Online Comment

Application H14-0578-18
Location Land adjacent: 33 Knight Street Pinchbeck Spalding PE11 3RA
Proposal Demolition of garage block and erection of two-storey dwelling

Name Ian Marshman, Historic Environment Officer
Address Lincolnshire County Council Places Team Lancaster House 36 Orchard Street LN1 1XX

Date Submitted 22-06-18
For/Against Comments

SITE BLOCK PLAN
SCALE 1:100

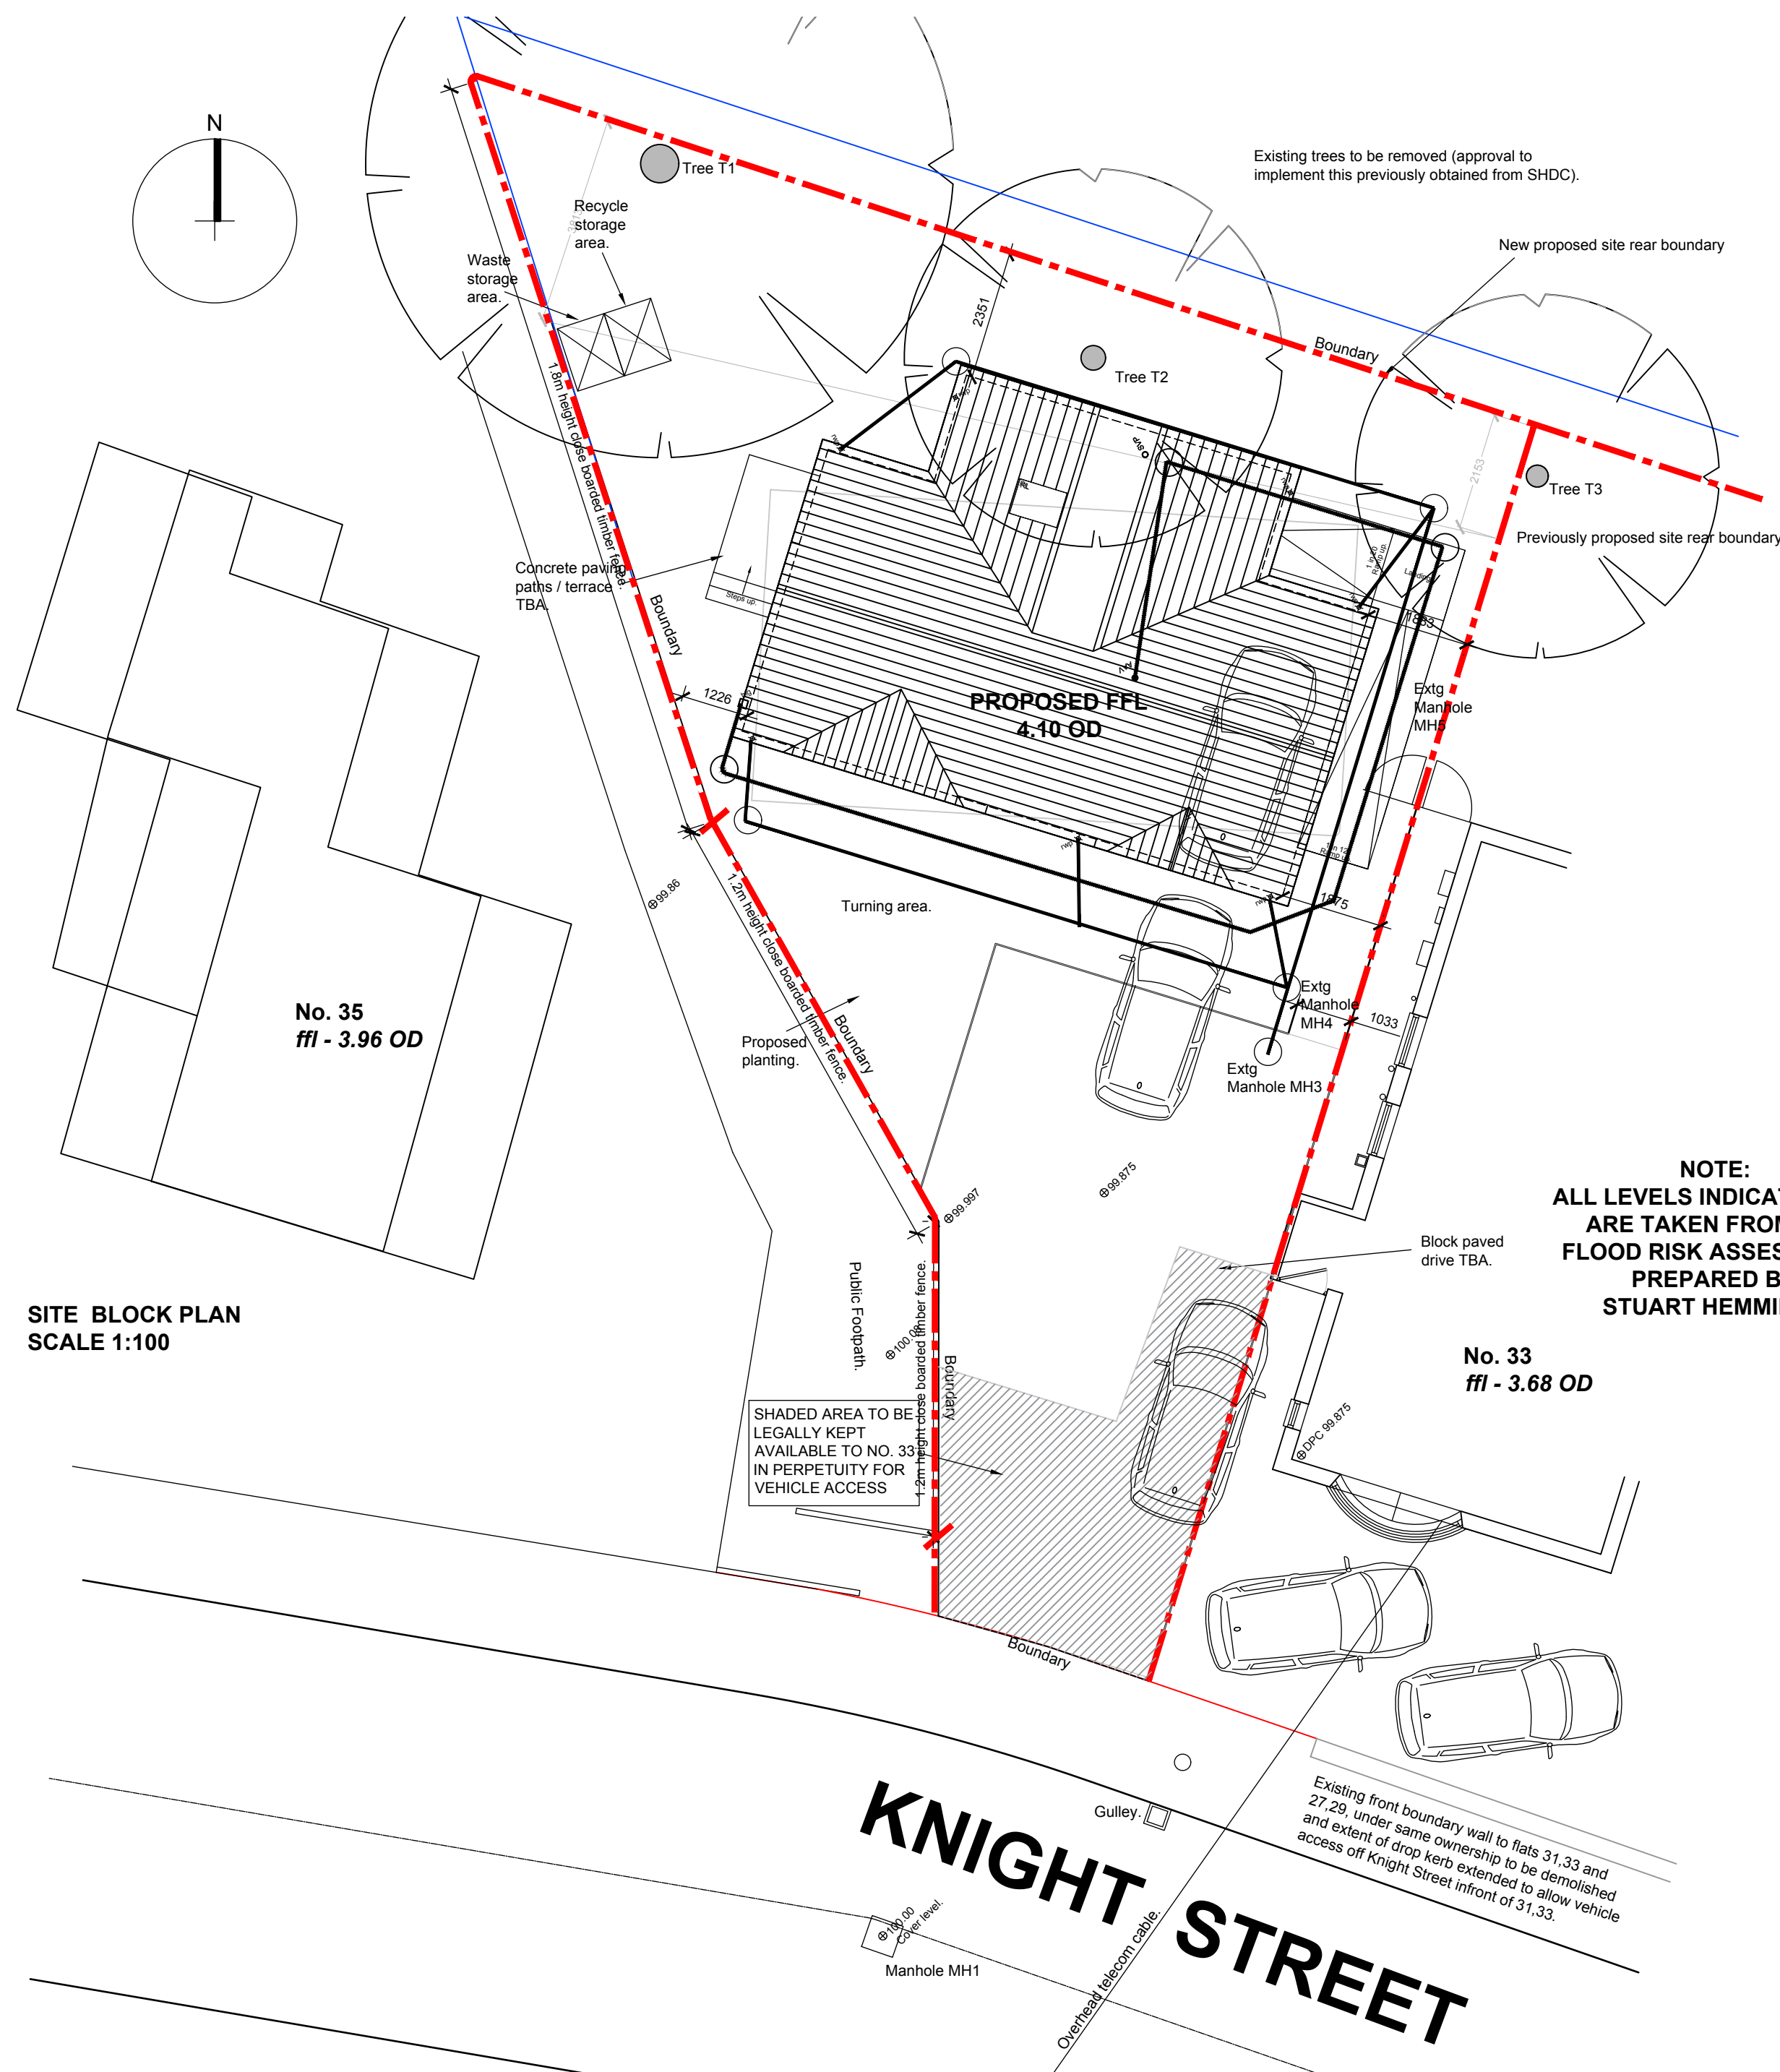
The proposal to demolish the entire wall between 27-33 Knight Street in order to create replacement car parking for the garages that are to be demolished is unacceptable in the conservation area. It would create a void in what has until recently been a continuous boundary treatment gently curving along frontages to Knight Street from the historic garden wall of the Grade II Listed Graft House, unifying properties of varying ages into a cohesive street scene. The loss of front gardens to be replaced by parked cars would also be a detriment to the character of this part of the conservation area. It is evident that several neighbouring properties have lately removed their garden walls to provide easier parking, but I can find no evidence that permission was granted for this, and SHDC has previously rejected similar proposals at 28 Knight Street on these grounds, which has been upheld by a planning inspector on appeal.

Street elevation as proposed
1:100
SCALE 1:100
SCALE 1:1

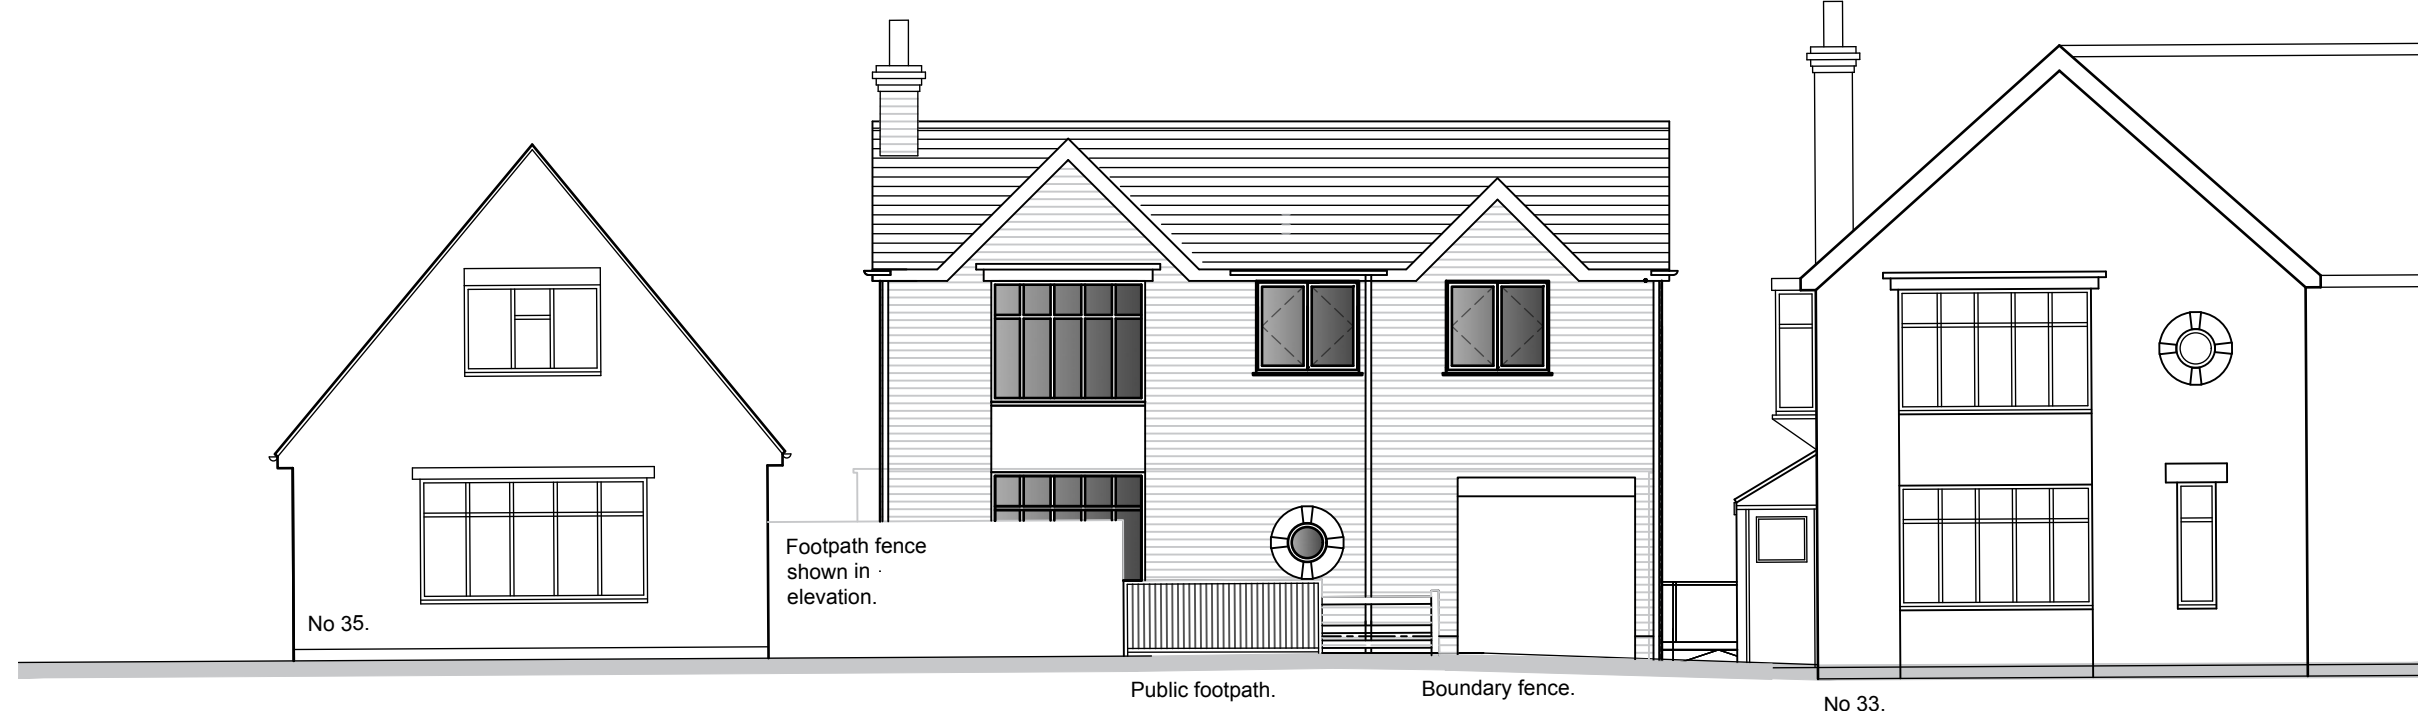
The proposed new house has taken some inspiration from the character of historic 1930s properties nearby, but does so in such a way as replicate many of the insensitive late 20th century alterations often made to interwar houses which detract from their contribution to the conservation area, and for which planning consent would usually not be granted. This includes using modern materials of poor quality such as reconstituted slate, green plastic fascias and soffits and white plastic windows in a later, 1970s replacement style.
